From: John Foot 
Sent: 30 May 2019 21:34
To: Planning
Subject: A/63/19/PL Comments and Objection

PROJECT
SHAFIQUES, THE SQUARE
ARUNDEL ROAD
ANGMERING
WEST SUSSEX
DRAWING TITLE
PROPOSED FLOOR PLAN, ROOF PLAN &
ELEVATIONS

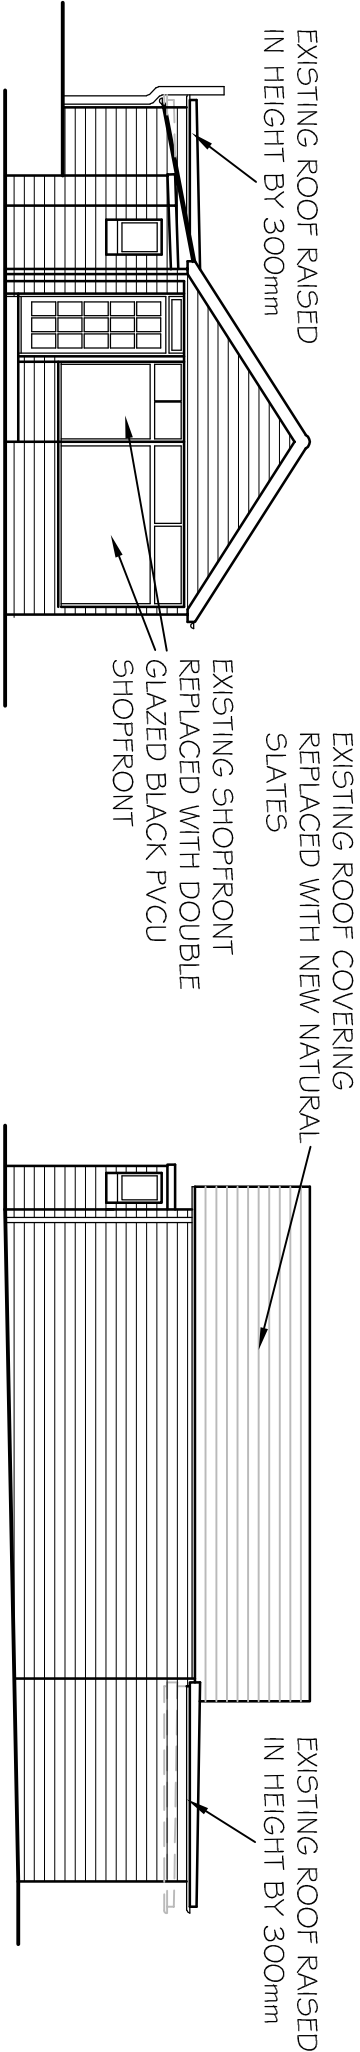
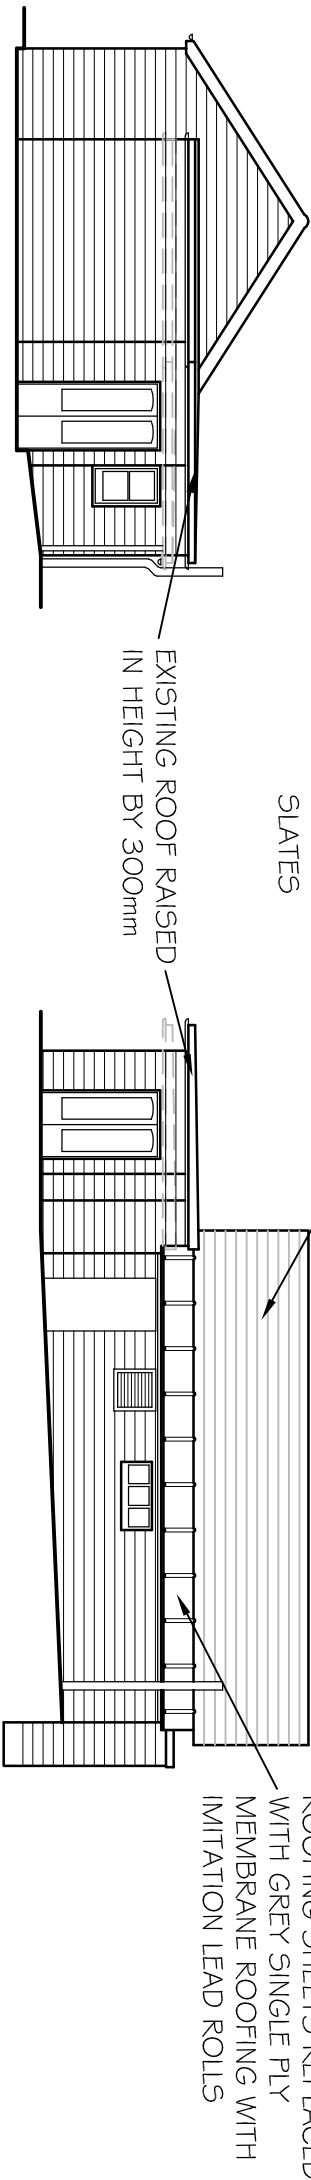
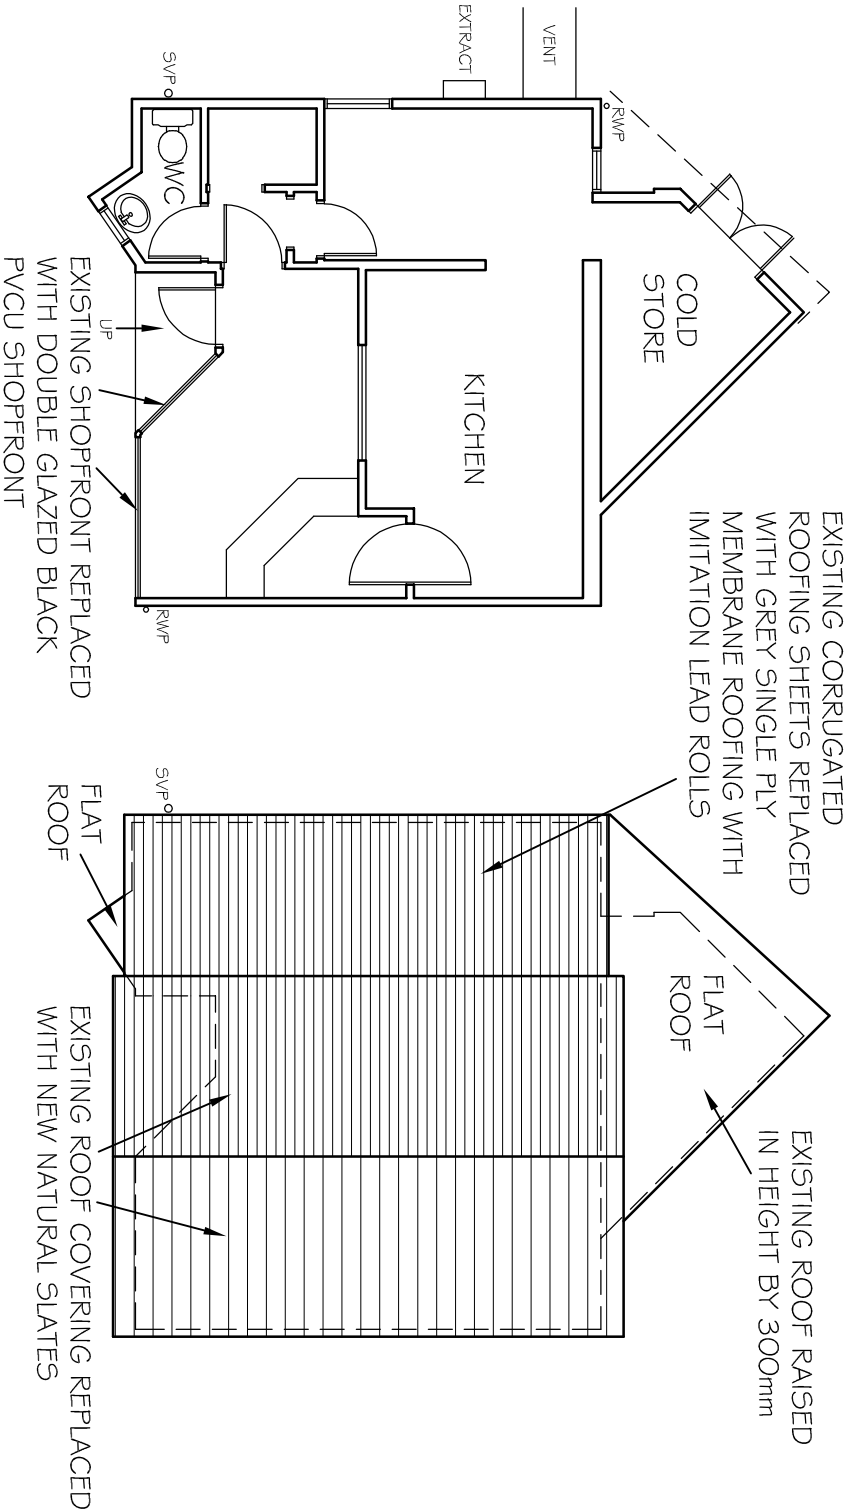
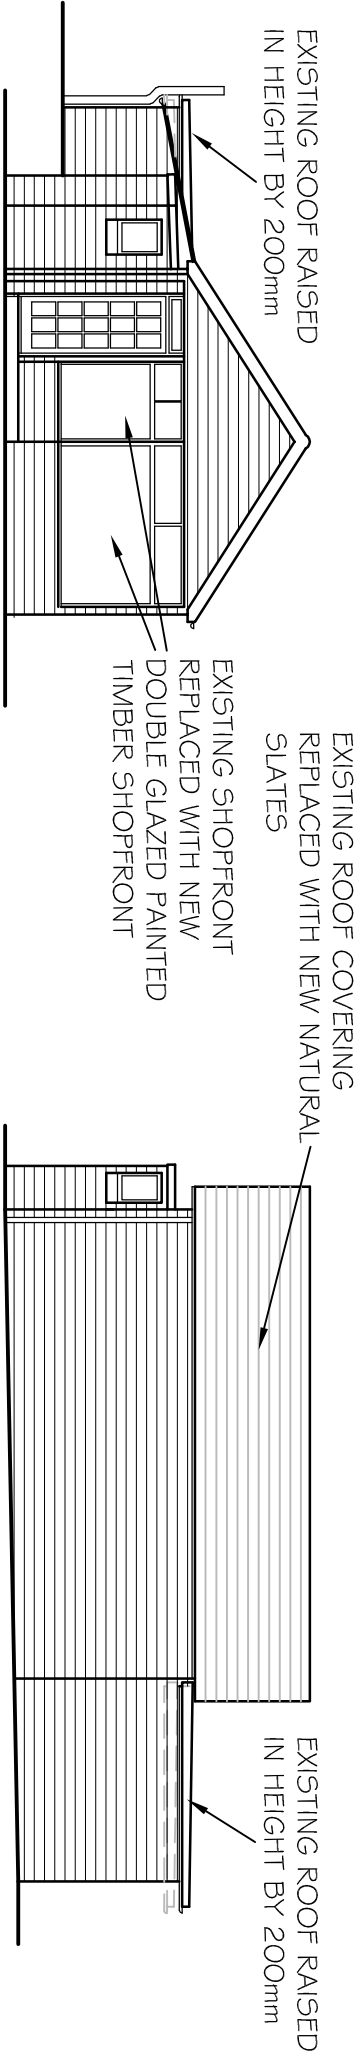
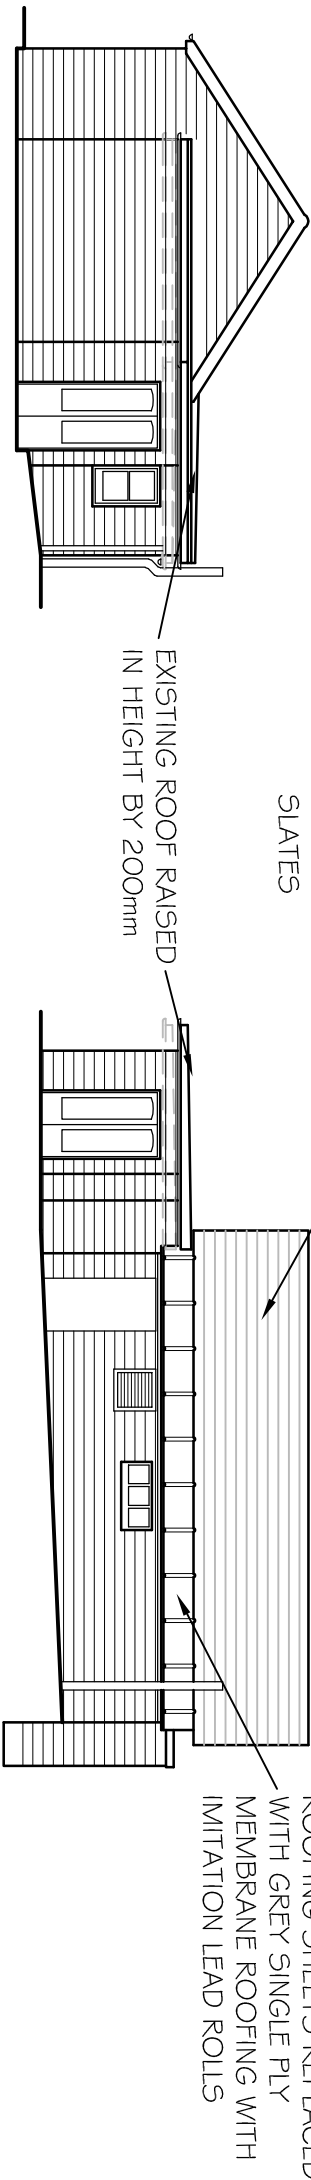
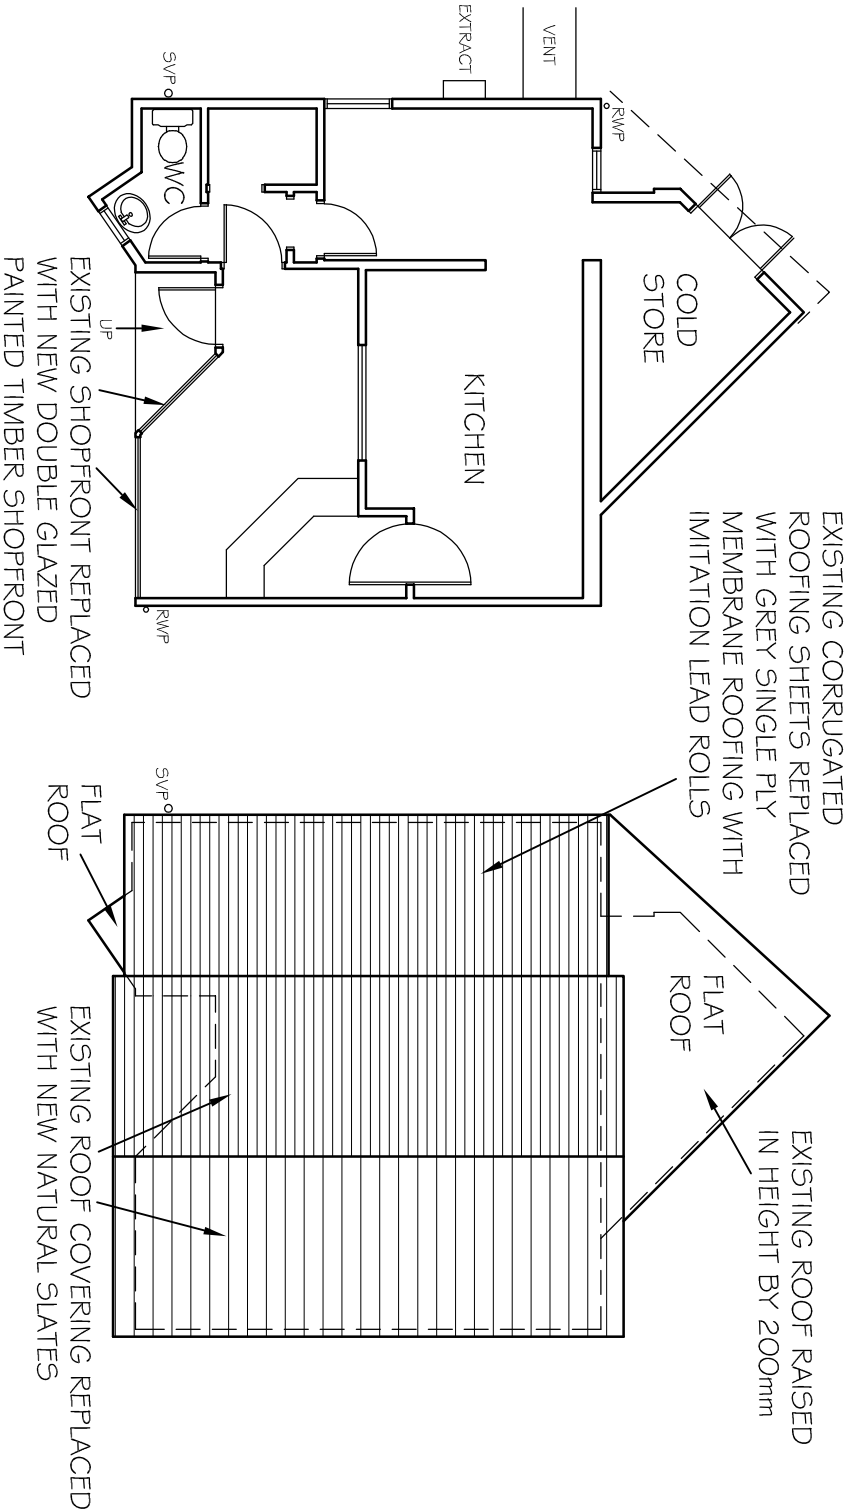
We are neighbours to Shafiques (Blaber Cottage) and are adversely effected by this application because of the increased obstruction of light to our rear kitchen window , See photo separate email, and it's unsuitability to the area.

It can be seen the structure at present occupies two thirds of the width of the window and three quarters of the height. An increase of 300mm of the height of the roof would occupy the last quarter. Owing to the closeness of the structure to Blaber Cottage, 0.52m at one end, the view to the sky and light is very restricted.

Application A/173/07 is relevant because it points out the unsuitability of the structure and materials in a conservation area. It would seem it was accepted because it is beneath the height of the flint wall adjacent to Church Road and was not visible to the general public. The proposed 300mm increase of the height of the flat felt roof would make it visible from Church Road and would be above the lower part of Blaber Cottage's roof and would certainly alter the appearance of Blaber Cottage's roof when viewed from Arundel Road opposite St Margaret's Church.

This proposal will make our present situation worse.
